Please ask for: Sian Eggington  
Email: [sian.eggington@terraquest.co.uk](mailto:sian.eggington@terraquest.co.uk)  
Telephone: 0121 2341390  
Our Ref: Y/90/20/HH  
Your Ref:  
Date: 17th September 2020

**Application for Planning Permission for Works or Extension to a Dwelling**

**Location:** Hobbs Court, Sunflowers Bilsham Road Yapton BN18 0JY

DRAWING
SITE PLAN
BOUNDARY DETAIL
 DRAWING No
324/01
 SCALE 1:500
 DATE OCT 20
 DRAWN LA
 CHECKED

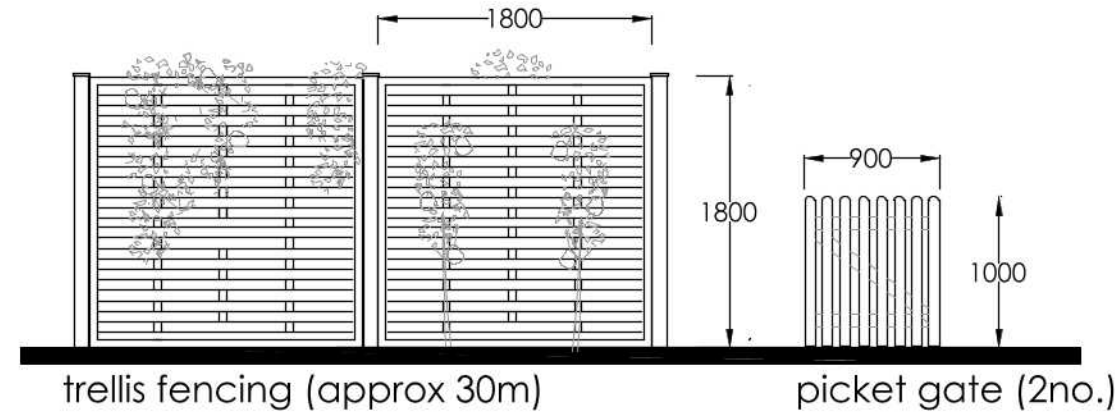
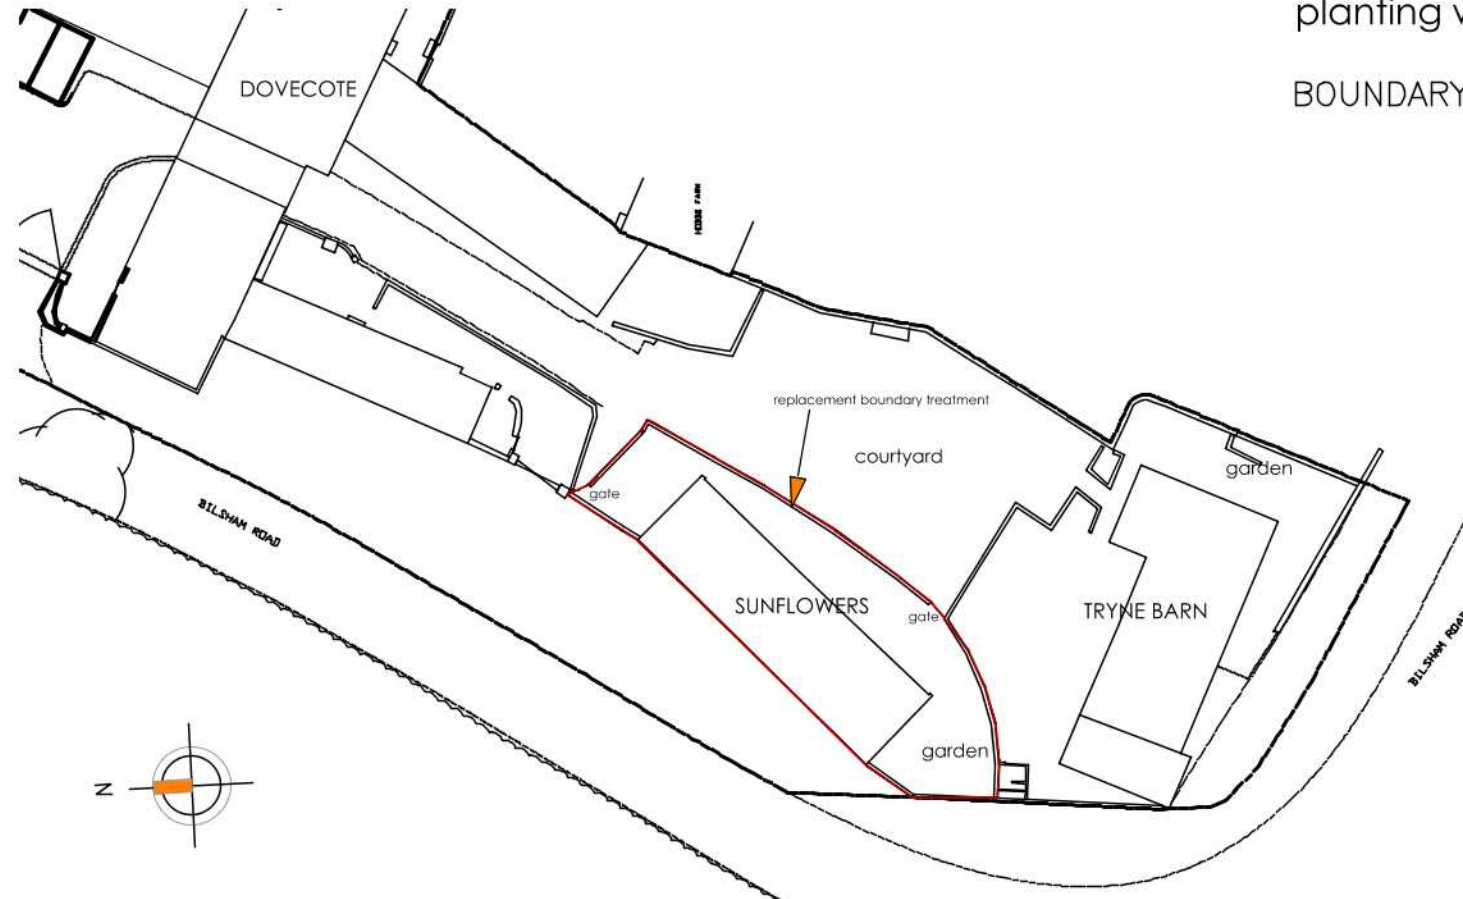
Elevations: Please provide scaled elevations of the proposed trellis stating the max height of the trellis. Please submit this at a scale of 1:50 or 1:100 with a scale bar.

Block Plan: Please provide a proposed block plan showing the location of the proposed trellis.

LOCATION PLAN AT 1:1250 SCALE

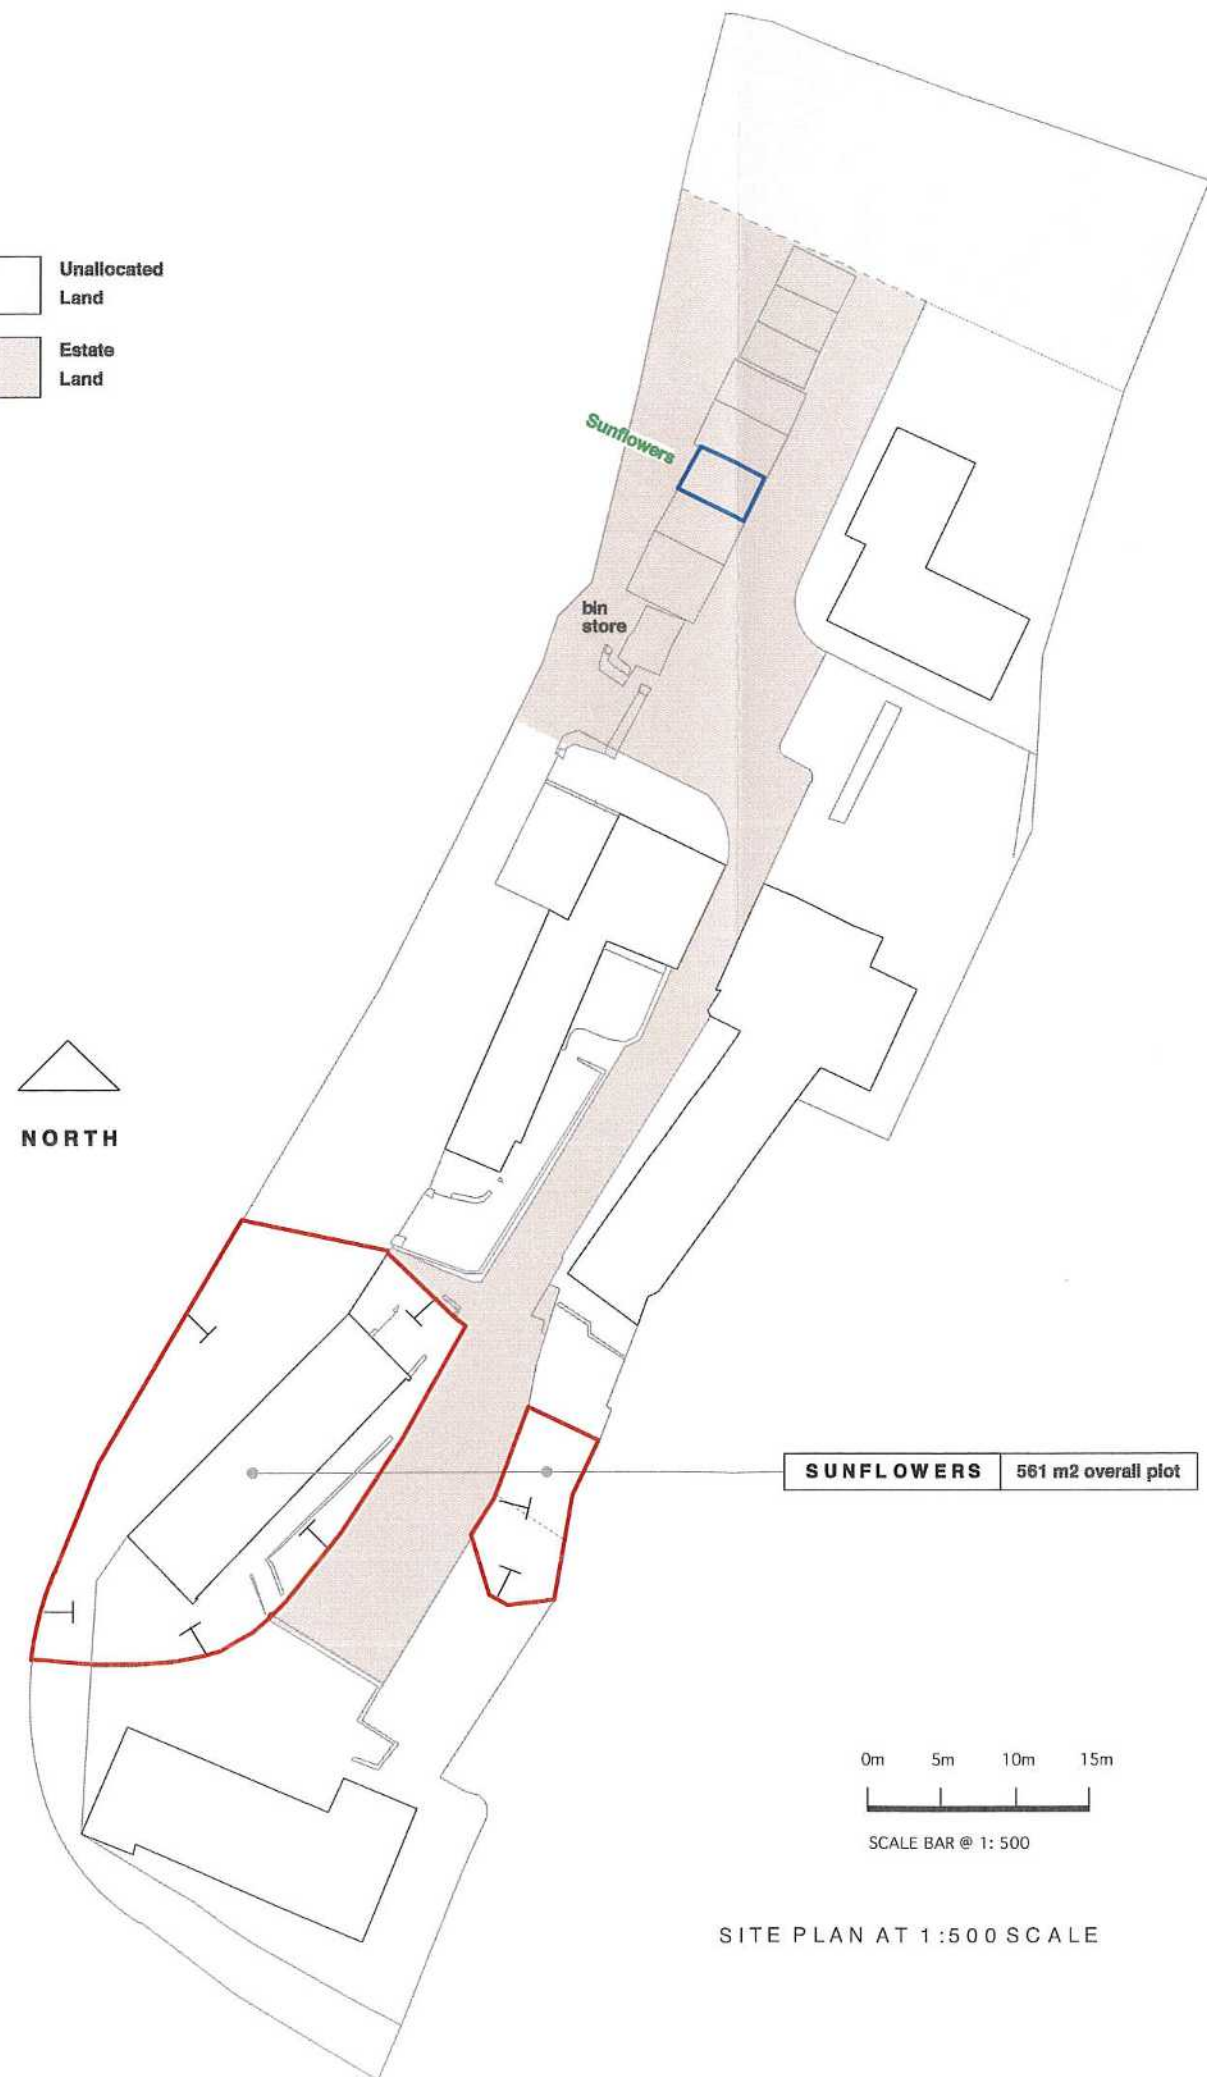
Location Plan: You are required to have a red outline around the proposed site on the block and location plan
